Please upload the below and attached to the above application: Further information (drainage).

Paul, our Civil Engineer has now had time to look over your comments and I'm pleased to attach revised documents to address these concerns with the following comments, direct from our Civil Engineer:

PERMEABLE BLOCK PAVING CAR PARK DETAIL
(Scale 1:20)

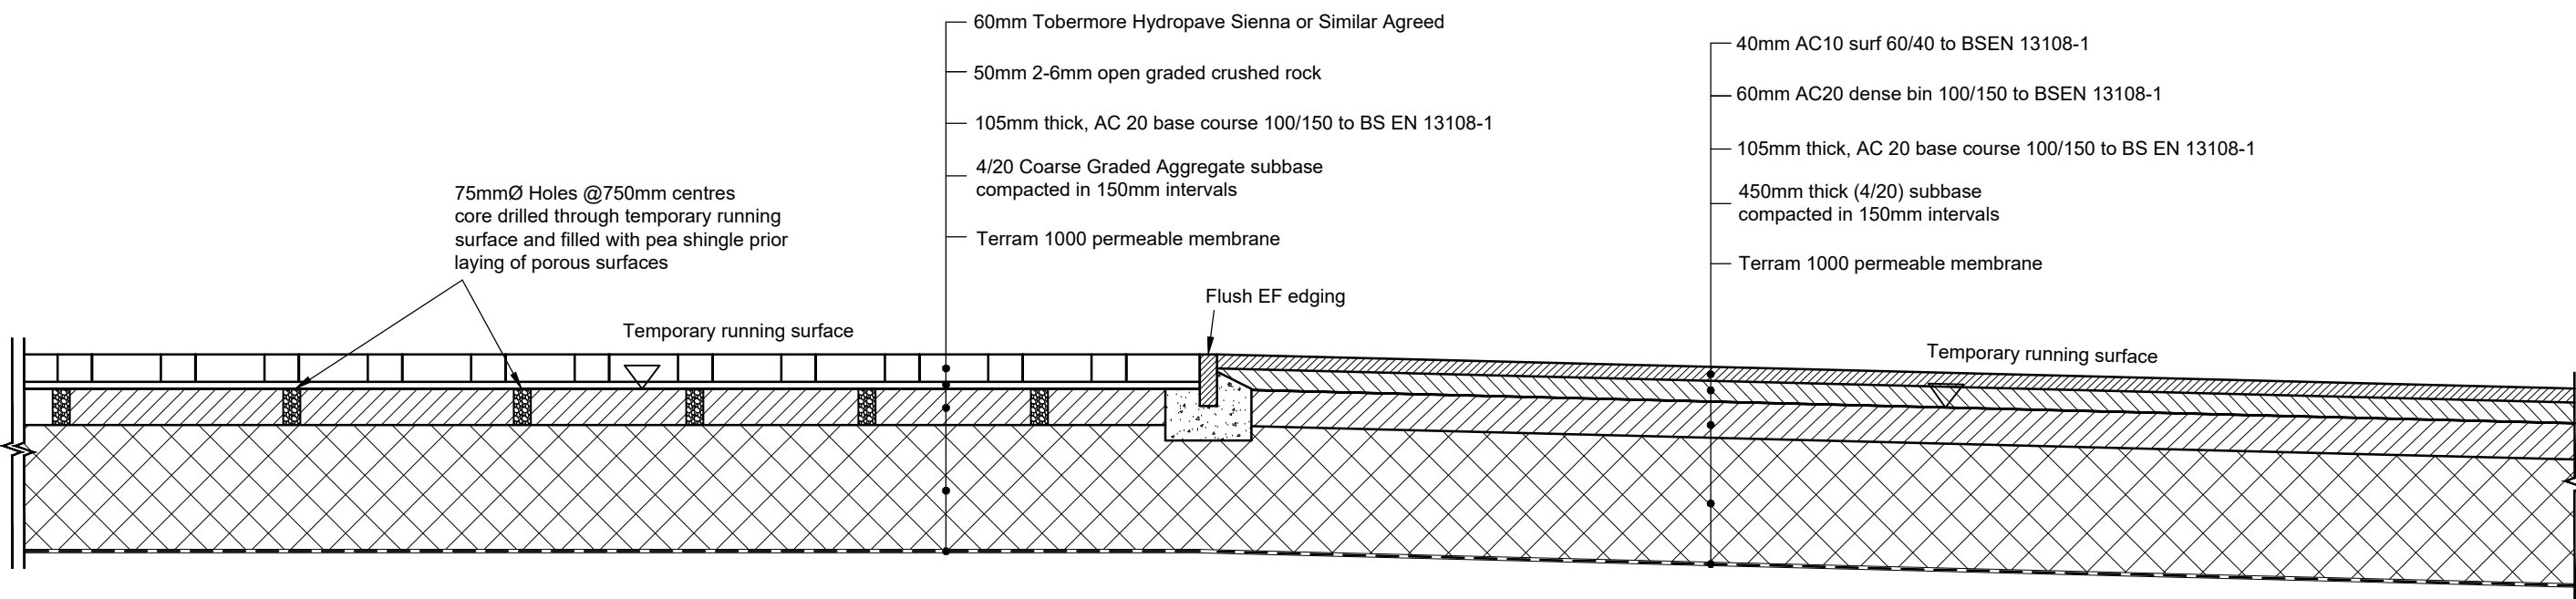
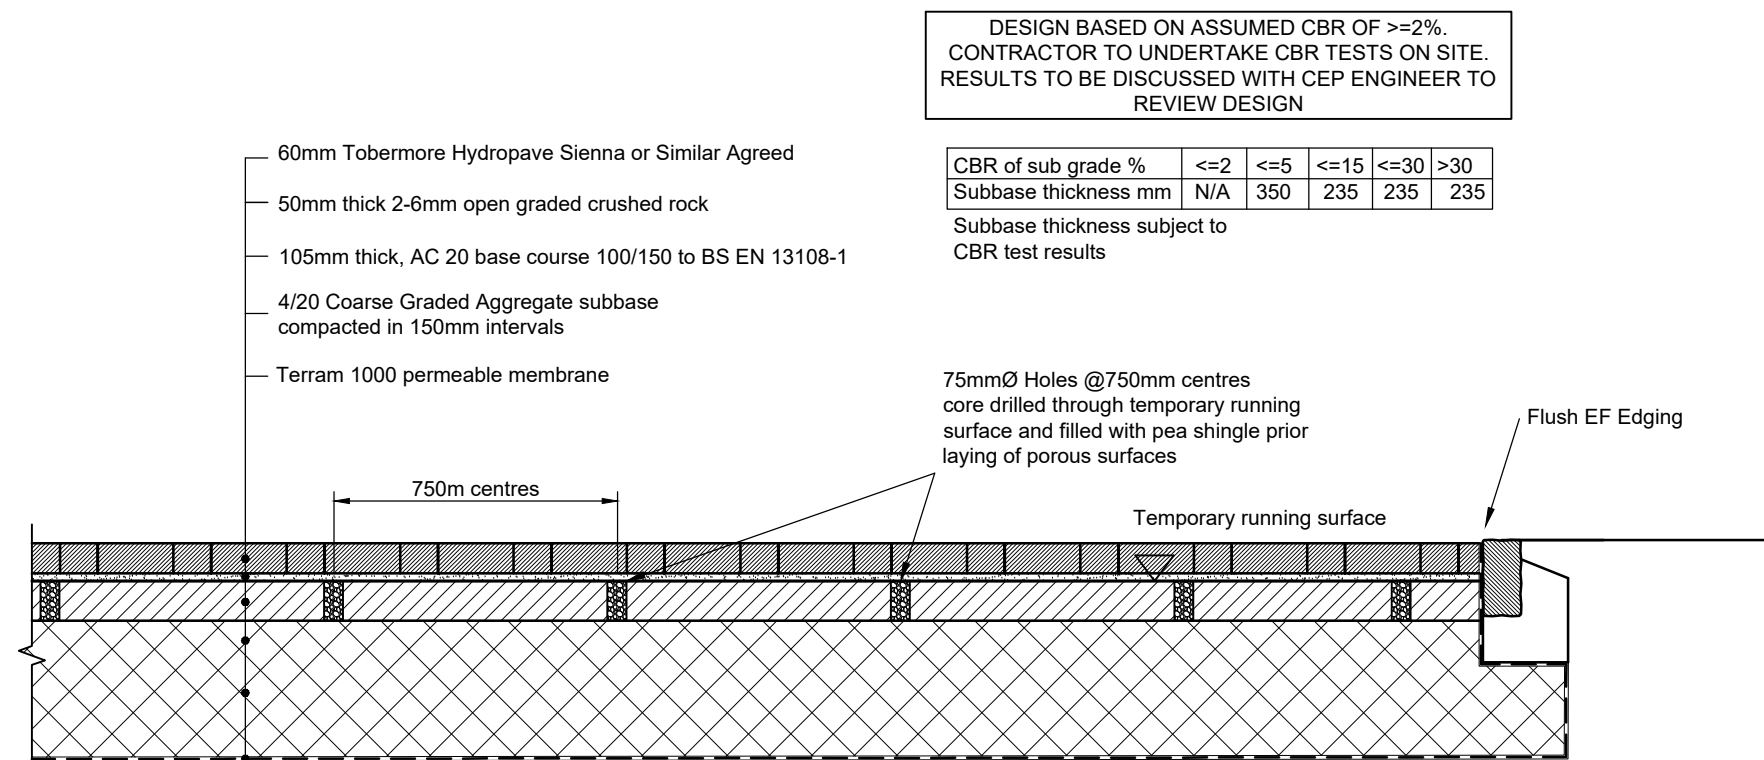
- 6) Added.
- 7) Added where required.
- 8) This is a design preference. We have not shown this as there no practical reason or benefit in doing so. The request would require laying asphalt directly onto the permeable membrane during the construction process.

- 9) The subbase thickness is dependent on the CBR values and not on the subbase thickness as demonstrated within the supporting calculations and information shown on drawings. Subbase thickness is based on an assumed CBR of 2-5% requiring minimum 350mm of subbase, storage requirements for the infiltration system for a critical 1 in 100 plus 40% climate change storm is a 240mm depth of subbase.

CLIENT		Mr Pete Mountford	
PROJECT		Repture Yapton West Sussex	
TITLE		Proposed Layout Drainage Strategy Plan	
DRAWN	DATE	PROJECT NO.	
M Pacifico	Nov 2019	2326	
ENGINEER	CHECKED	DWG NO.	REV.
M Kempshall	SRM	101	B
SCALE	1:200 @ A3

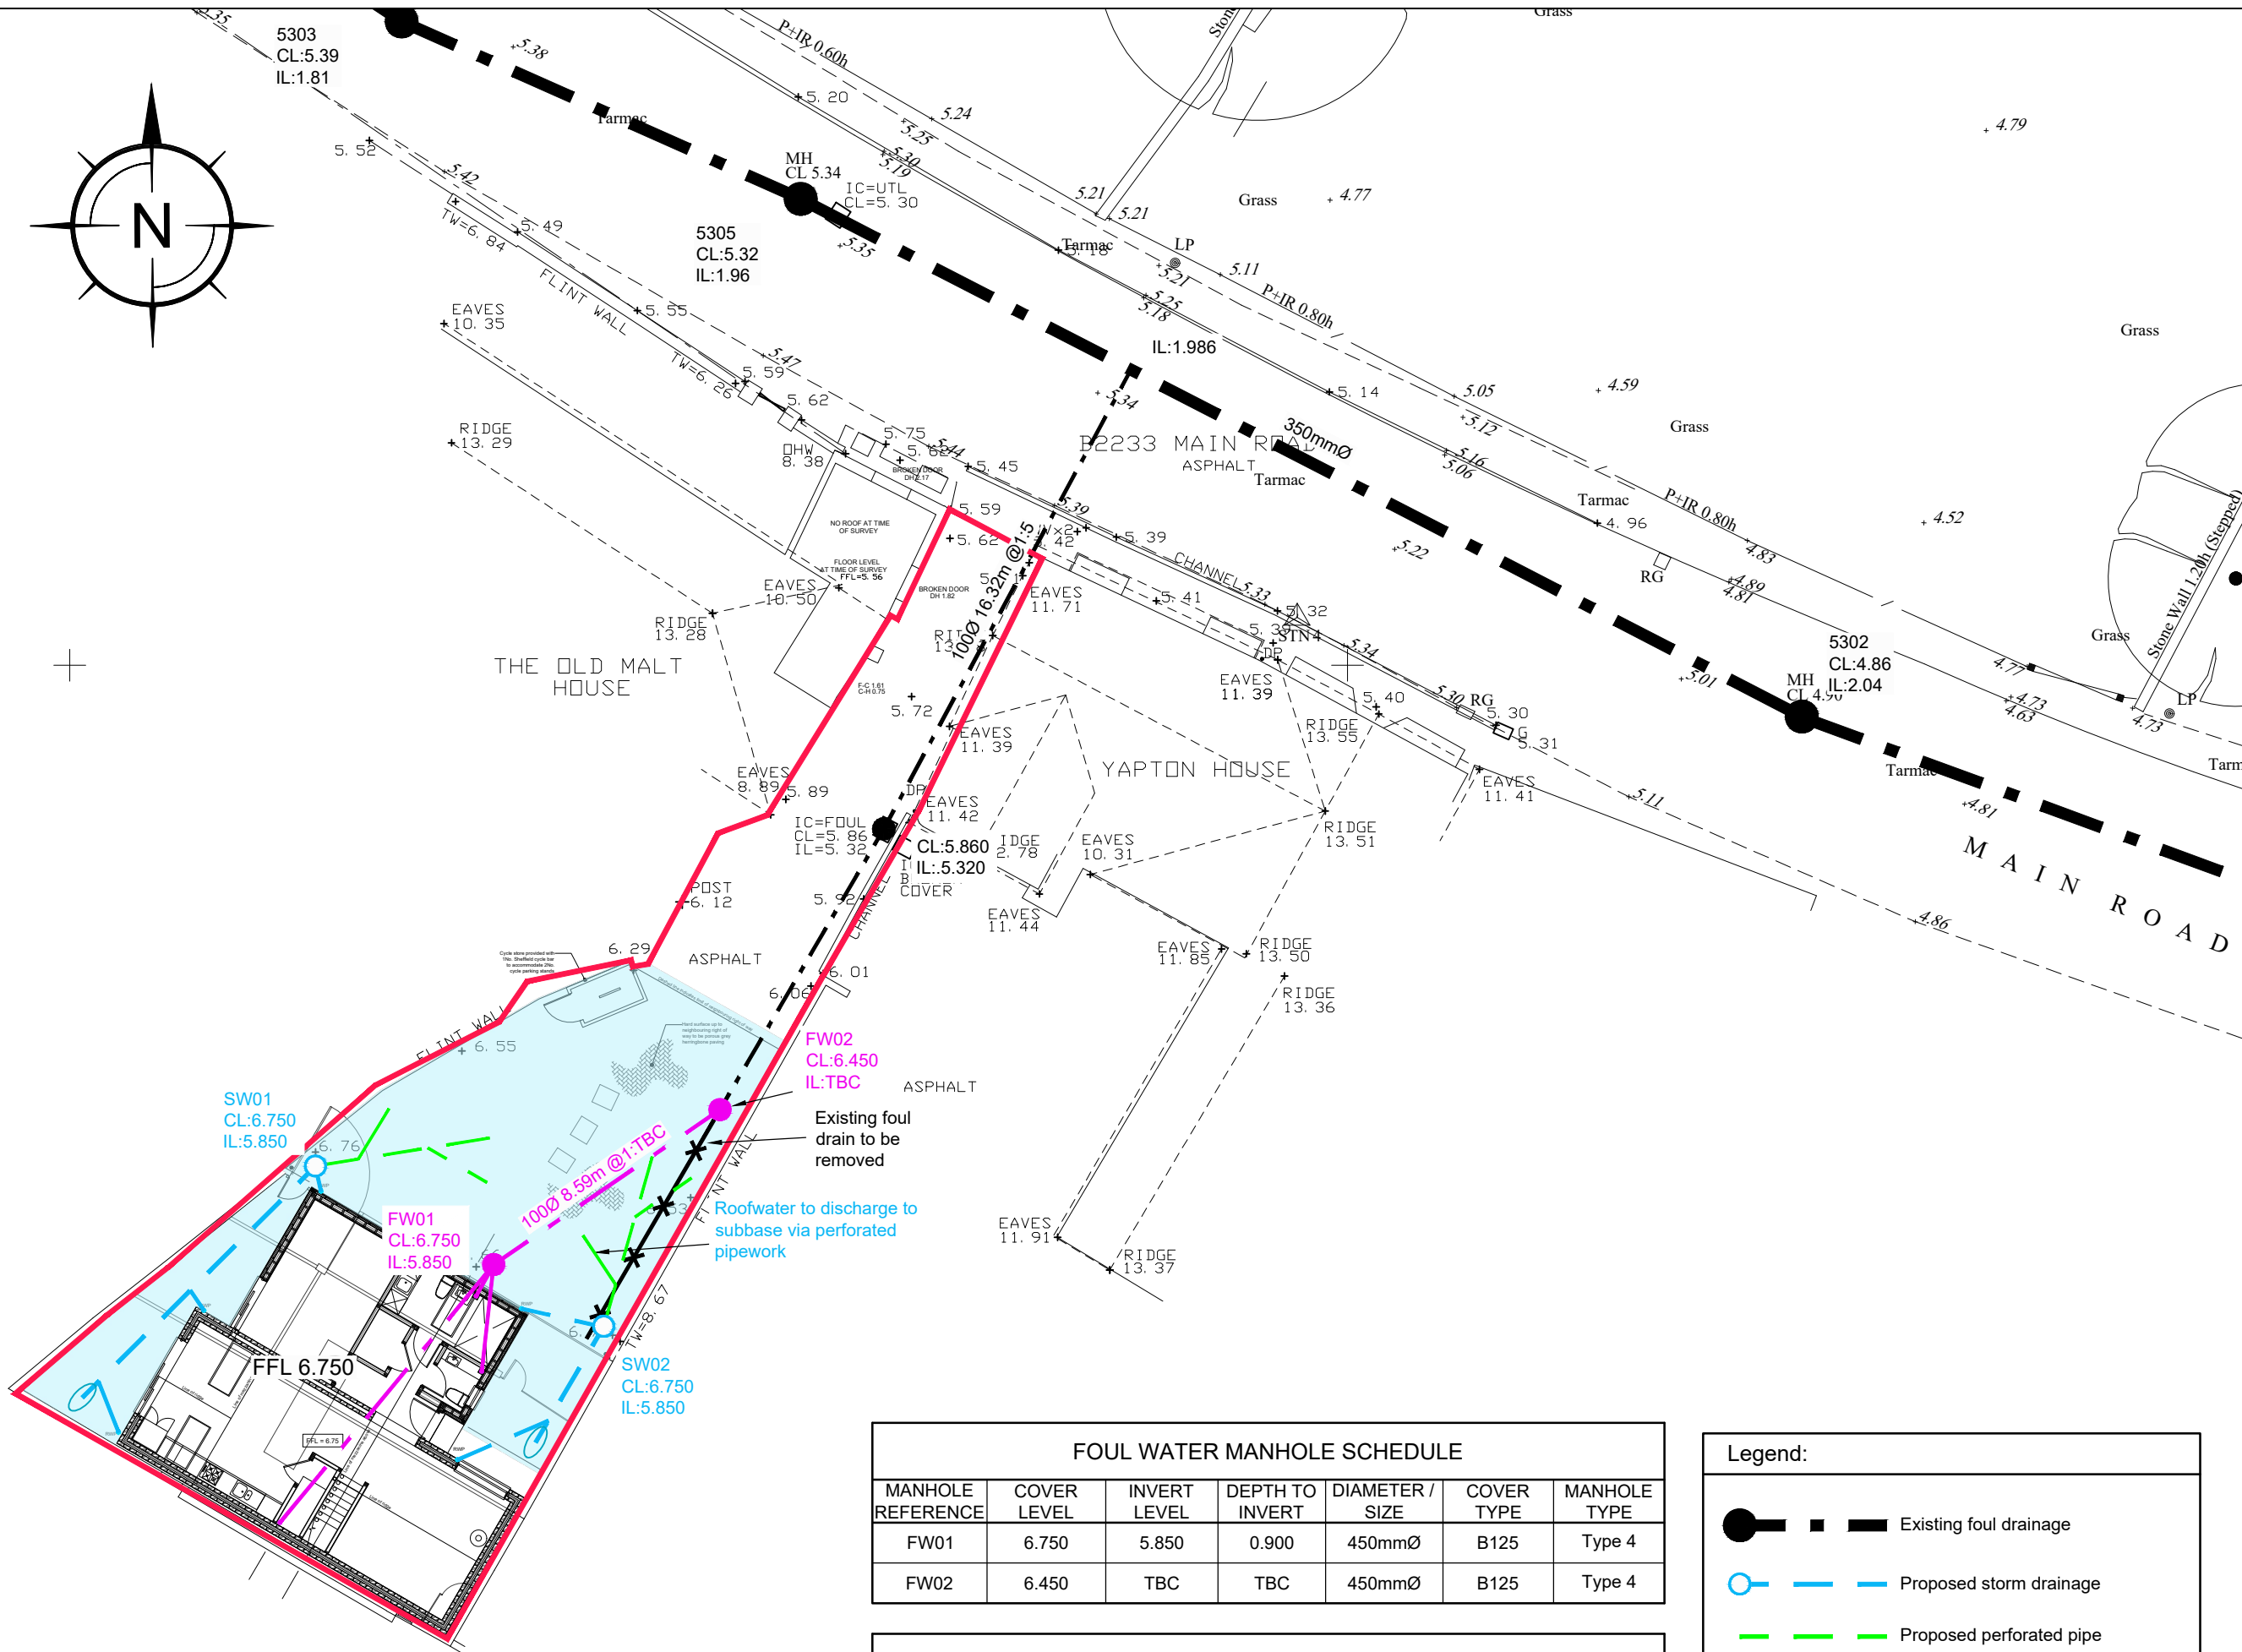
- 1) A copy of winter infiltration testing and groundwater monitoring information is attached at the rear of the report.
- 2) The extent of the proposed new paving is shown on the drawings which is reflected in the areas of the infiltration blanket within the supporting calculations. The drainage strategy plan, attached again for quick reference, shows no surface treatment changes to the Northern end of the site. The blue shaded area is the area subject to resurfacing.
- 3) This is a design preference and not a planning related requirement which is beyond the remit of a consultee at Planning Stage. We are the designer and can choose between either the use of perforated pipe or diffuser units as both are acceptable designs. We have consulted with our Client and in this instance they are happy to use a

- 5) Added where not shown – The foul water pipe connecting proposed FW01 and FW02 will not be known until construction and the minimum fall has been stated.

- 10) Additional levels added and subbase thickness updated to reflect the assumed CBR.
